Engineers Comments Regarding Surface Water Drainage

Application Reference:	BE/16/25/RES	Reviewer Reference:	ADC/SB
Planning Officer:	Emma Sheppard	Date of Review:	13/08/2025
Site Name:	Land at Oldlands Farm Newlands Road Bognor Regis PO22 9NN		
Application Description:	Approval of reserved matters following outline consent BE/150/22/OUT comprising of 3 No. units within Class B2 and/or B8 of the Use Classes Order (including ancillary office provision) with associated enabling works, parking, landscaping and sustainable drainage system with access off Newlands Road. This application is in CIL Zone 4 (Zero Rated) as other development.		
Assessment Number:	2 of 1

Drawn:	J.Arnold	Reviewed:	T.Jones
BWB Ref:	243912	Date:	29.11.24
Scale@A1:	1:500	Status	Rev
FOR COMMENT			
Project - Originator - Zone - Level - Type - Role - Number			
243912-BWB-EXT-XX-D-C-0530			
S3 P01

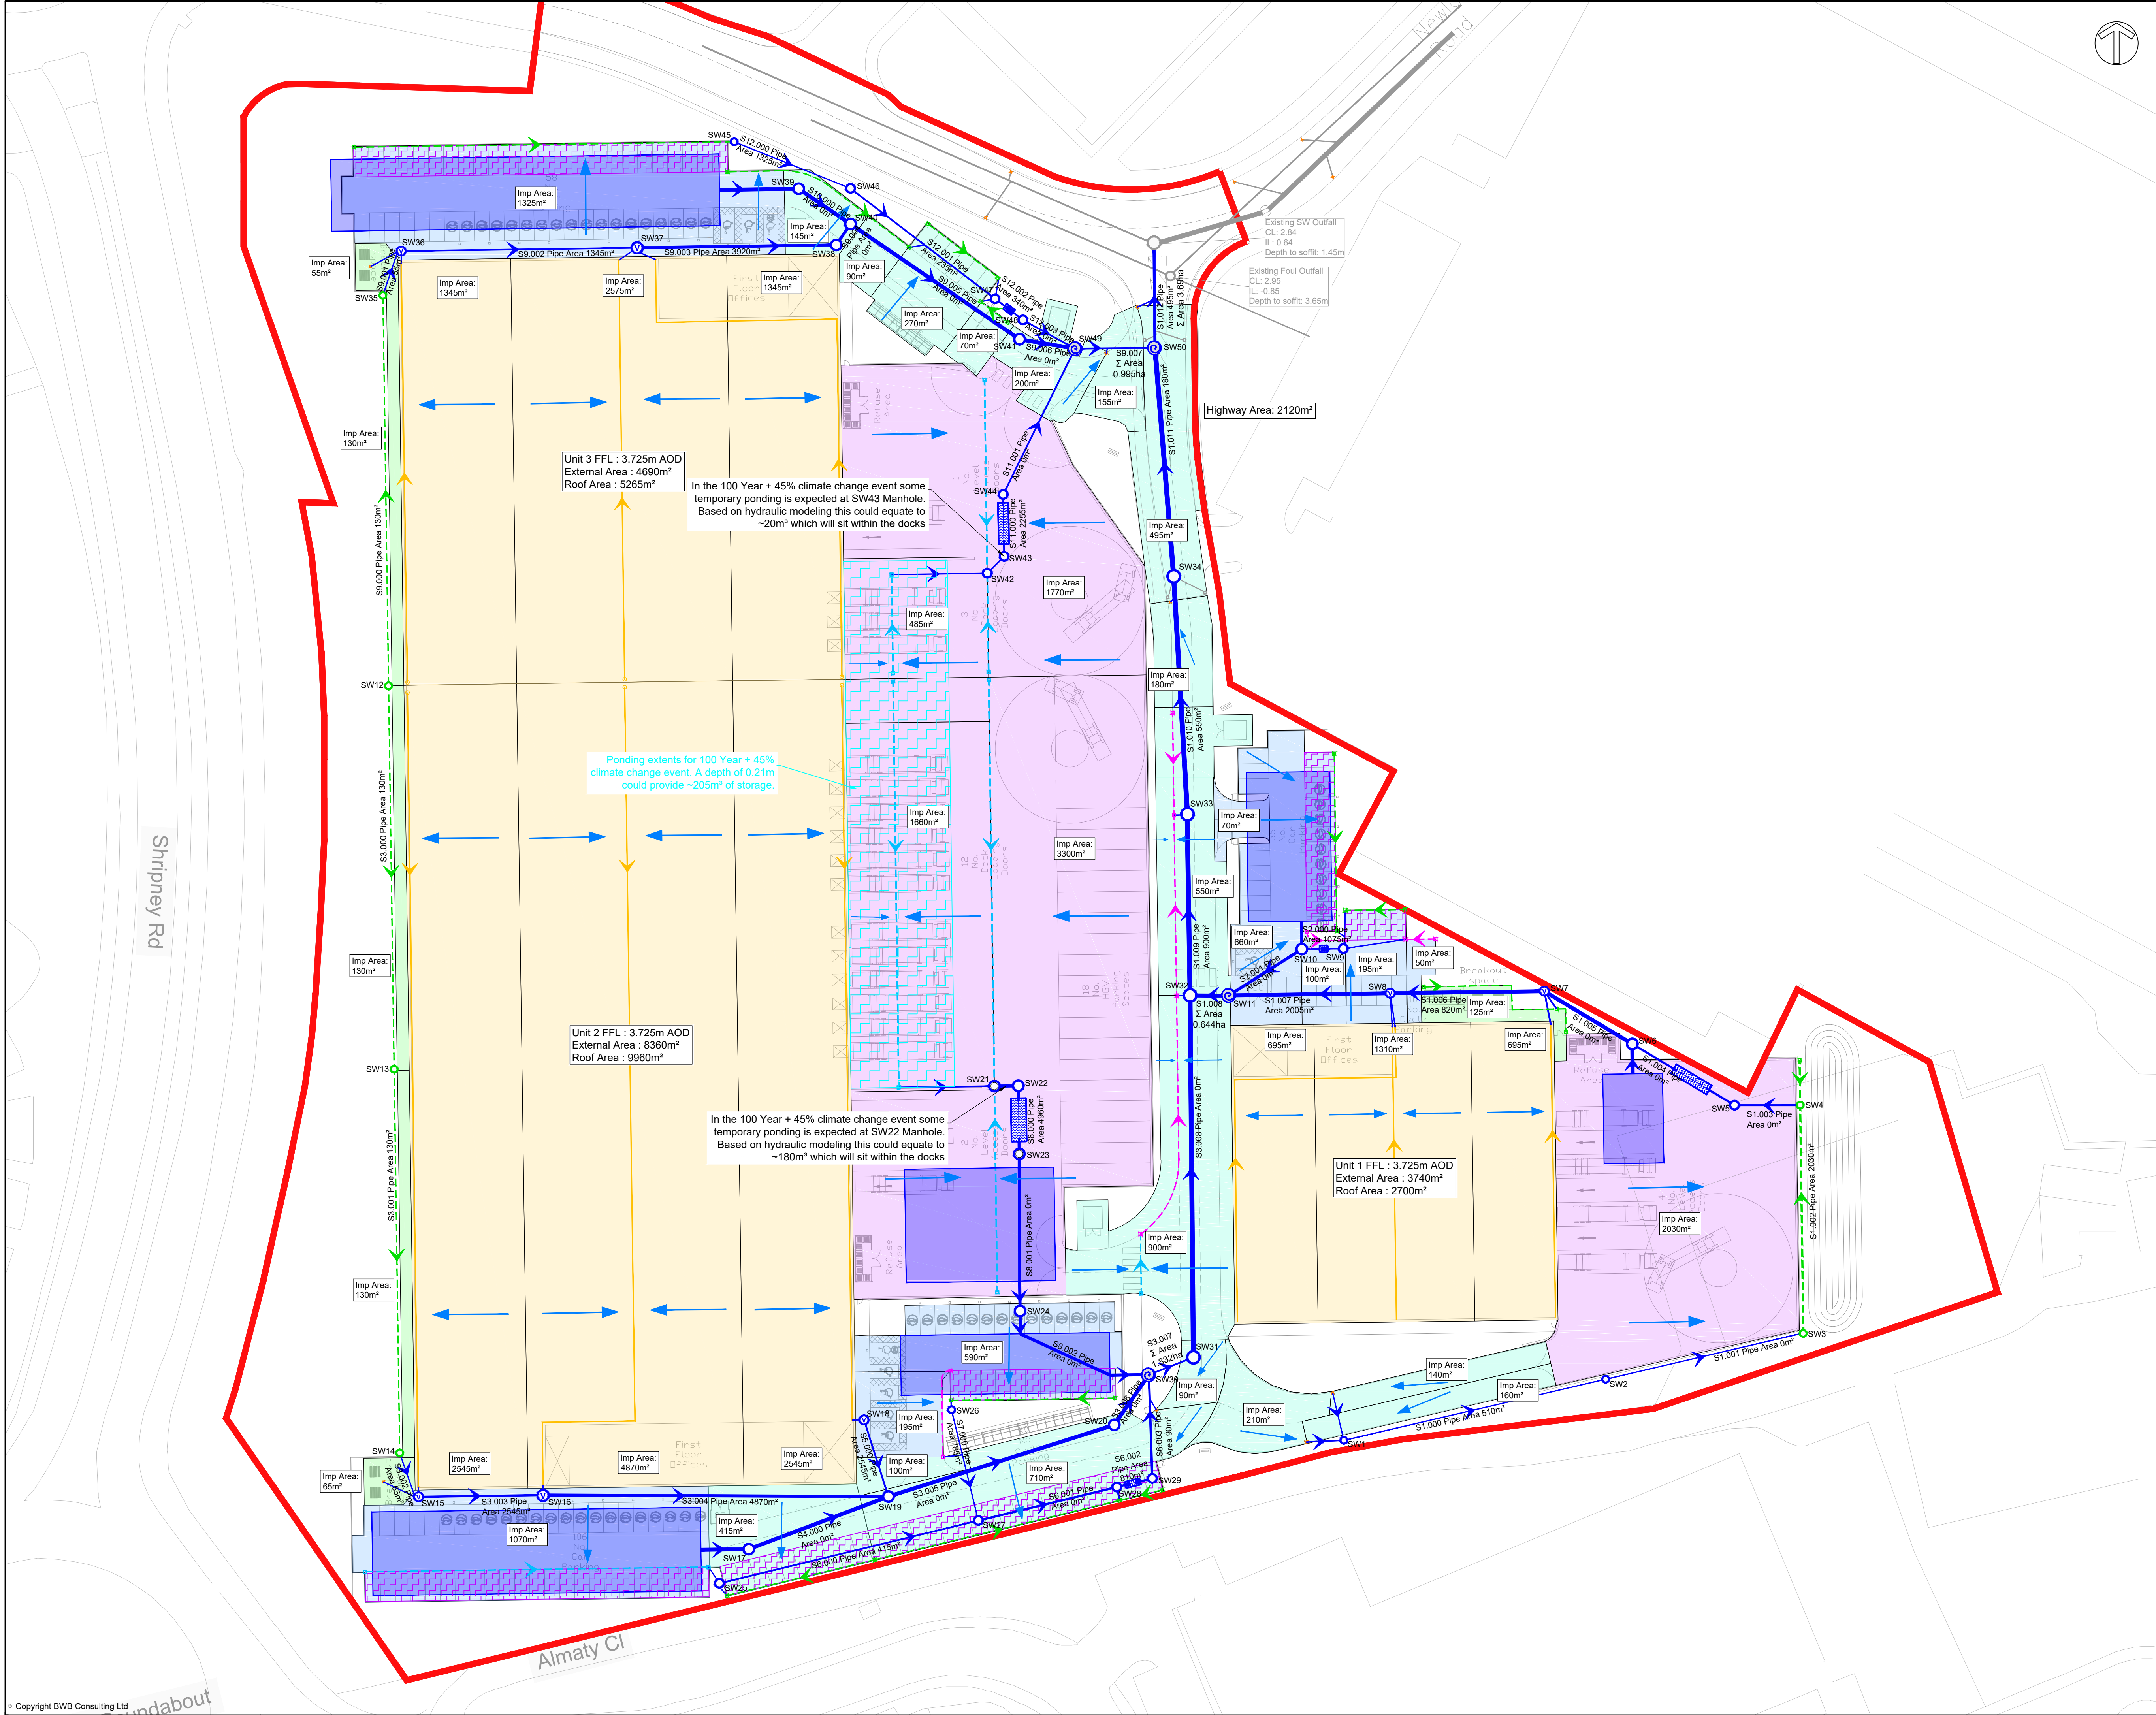
- BWB Response to LLFA Objection linked to sup 1.8.25. Referred to as the **BWB August Response**.
- Drainage Catchment Plan Dwg. No. 243912-BWB-EXT-XX-D-C-0530 Rev P01 (x2) **both need to be superseded as substitute plan Rev C02 is contained within "Response to LLFA and Arun District Council Drainage Engineer comments 07.07.25".**

DRAINAGE STRATEGY IMPORTANT NOTES

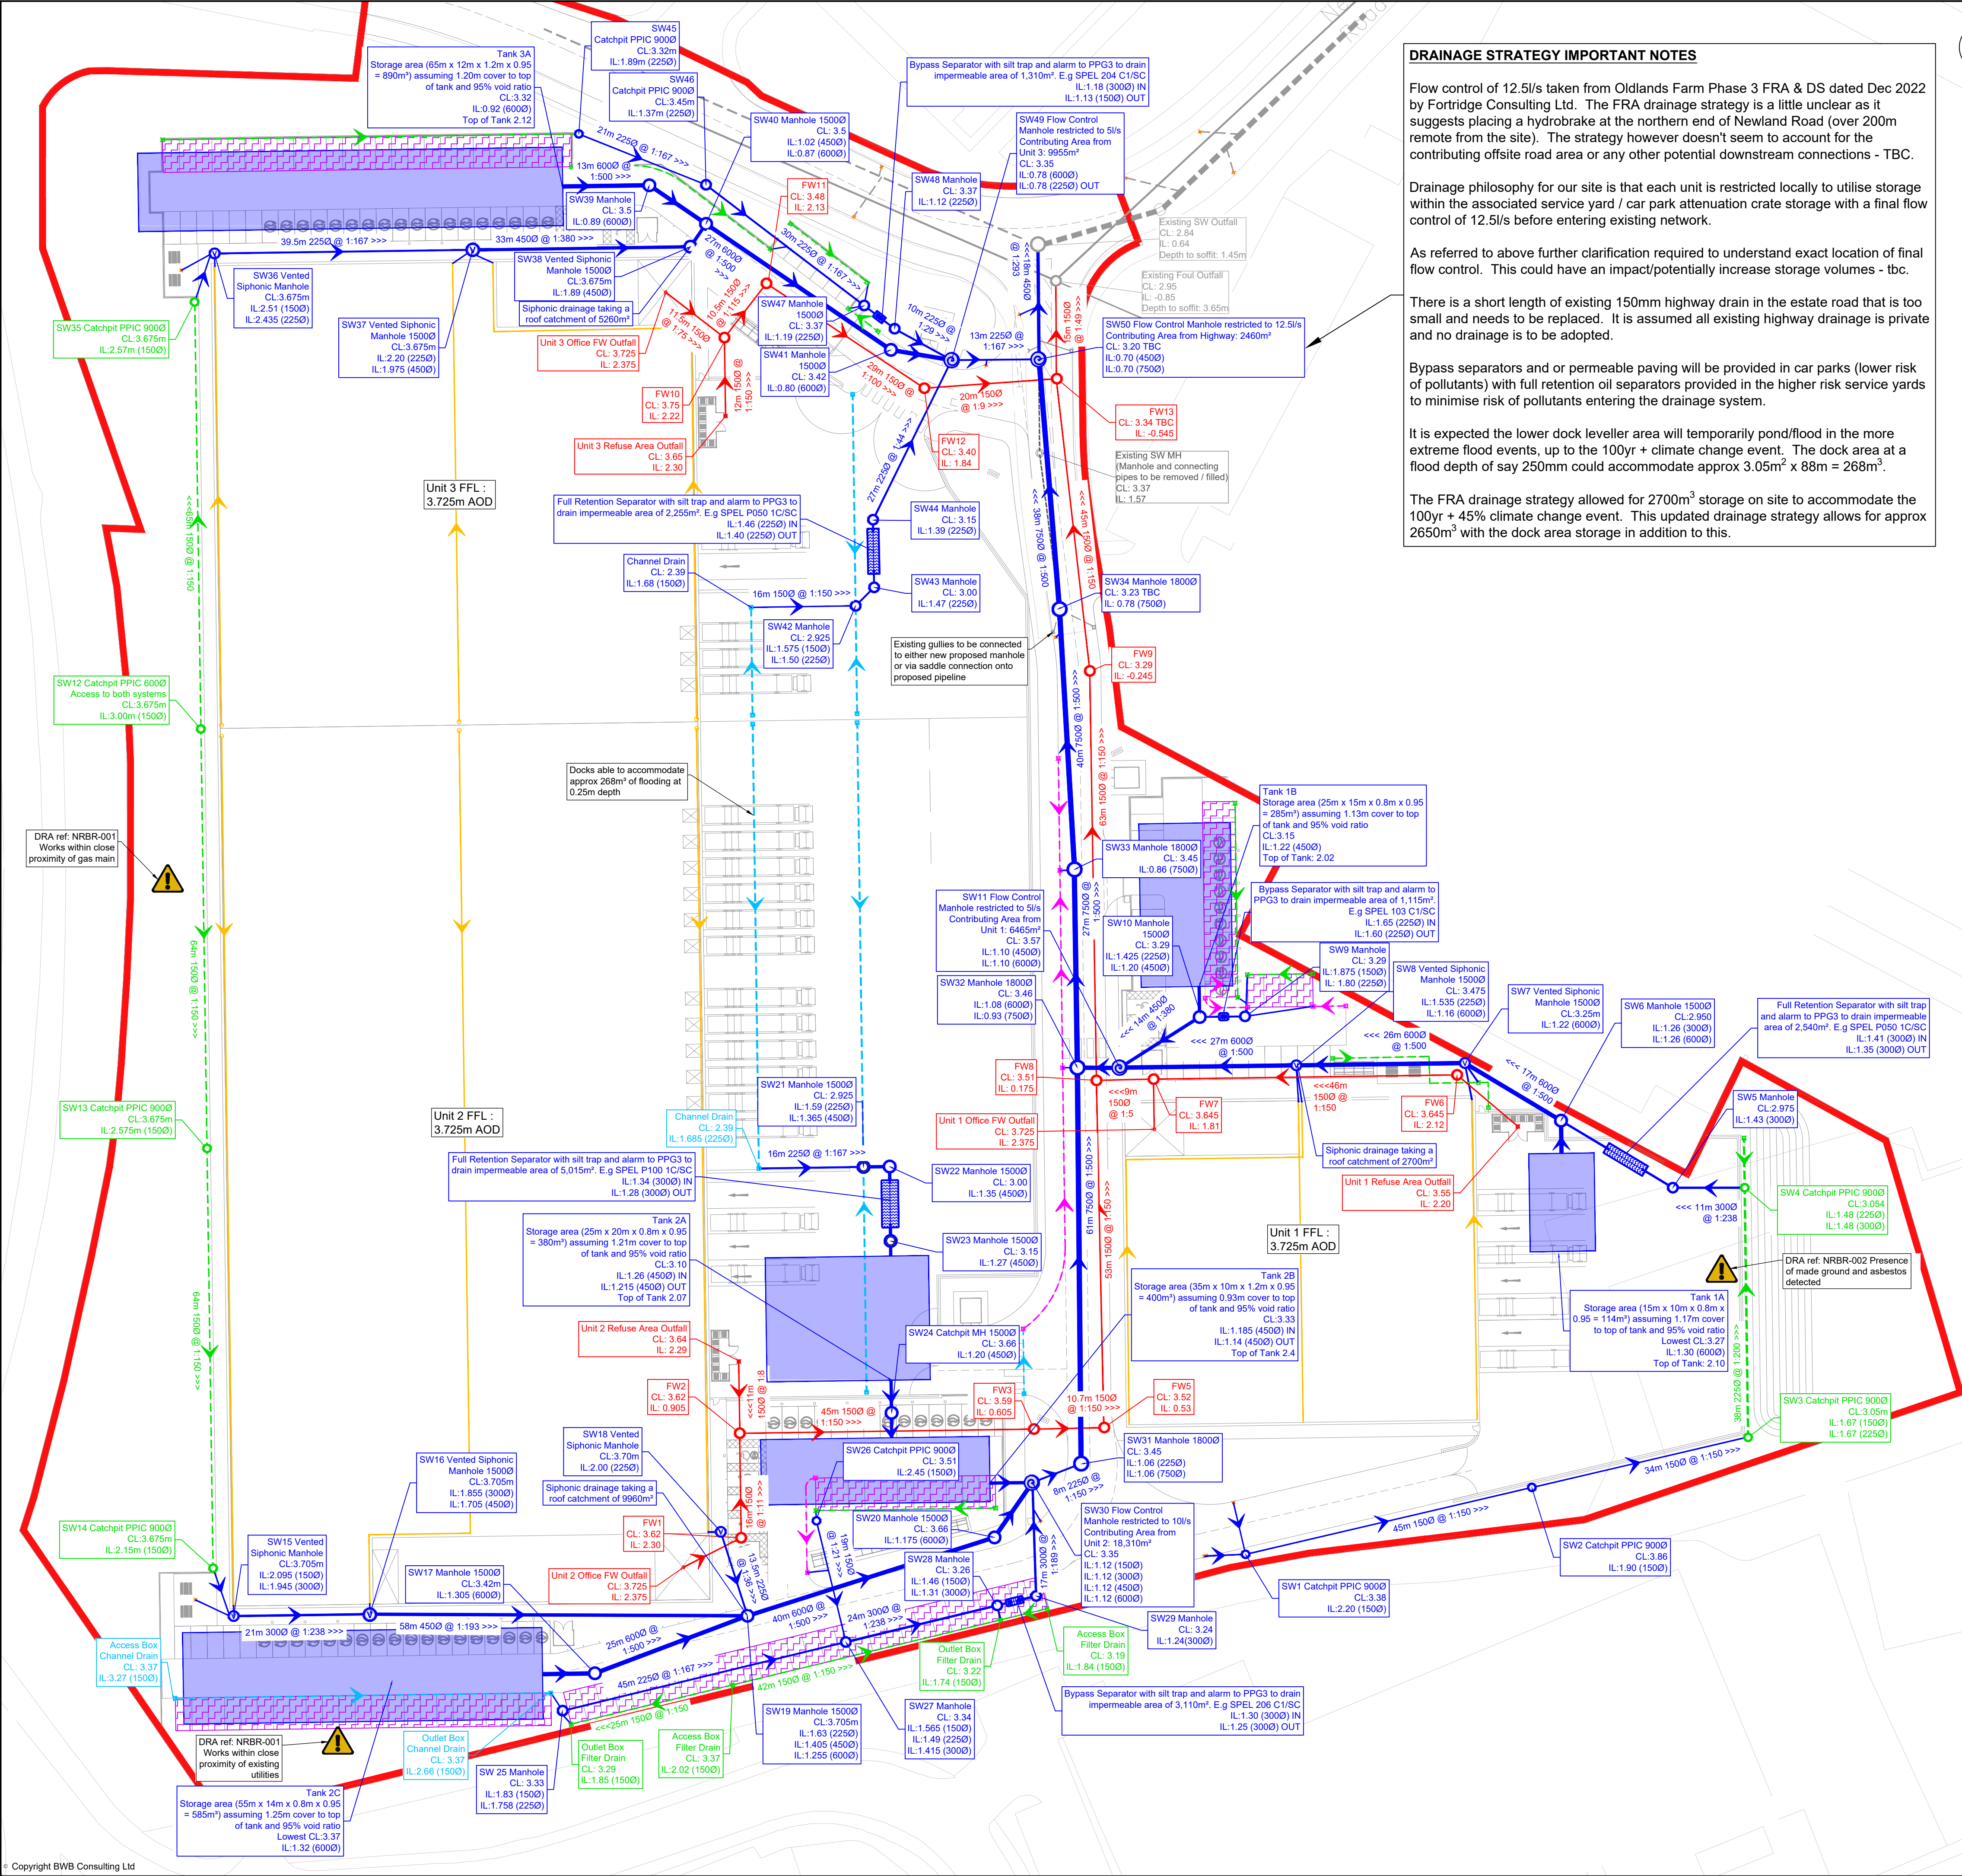
The NSfS offer the option to demonstrate compliance on both rates and volumes by restricting discharge rates to 3l/s/ha. For this site, of a contributing area of 3.69ha, that would equate to 11.07l/s. This is a slower rate than the 12.5l/s that is proposed. If discharge rates need to be restricted further then additional storage will be required to ensure that flood risk will not be increased. This may impact the scale and layout of the proposed development.

The modelling shows that there is a total flooded volume of 26.5428m³ on the critical 3.3% AEP + 40% event. This conflicts with standard 3.35 which states that:

Insufficient information has been presented to demonstrate that the temporary flooding allowed for within the design for the critical 1% AEP + 45% event meets national standards. Where flooding is allowed for this event, it must be controlled as prescribed. There is flooding from multiple nodes across the proposed development. The designer has explained that some of this flood water will be stored within the lower dock area of units 2 and 3, and within unit 1 service yard. This may yet prove to be acceptable, however, there are other areas of flooding on the site, most notably at node 50, the Hydrobrake prior to the outfall at the access to the site. This node shows a flooded volume of 25.8989m³ and cover levels appear to fall off site.

Where a system is allowed to flood on the 1% AEP + 45% event, detailed levels information is expected to be submitted to ensure that the flooding is controlled and will remain on site. The designer is expected to accurately demonstrate where flooded runoff will flow, be stored and then collected by the SuDS system.

There appear to be inaccuracies in the submitted model, with some nodes modelled larger than shown on the plans and the permeable paving porosity shown as 1.00. Both factors will artificially increase the storage that is modelled and therefore the flooded volume is likely to be underestimated. Cover levels are not identical between the model and the layout; however, these tend to be cautiously modelled. Every node and pipe within the model have not been assessed due to the anticipated changes required to the design.

There is the potential for conflict between proposed trees and drainage infrastructure on the site. As landscaping is to be determined by this application it is expected that these conflicts are resolved. Most notably on the east side of the site where a tree is proposed over an inspection chamber. There are also trees positioned near the lined permeable paving without an indication of their potential growth.
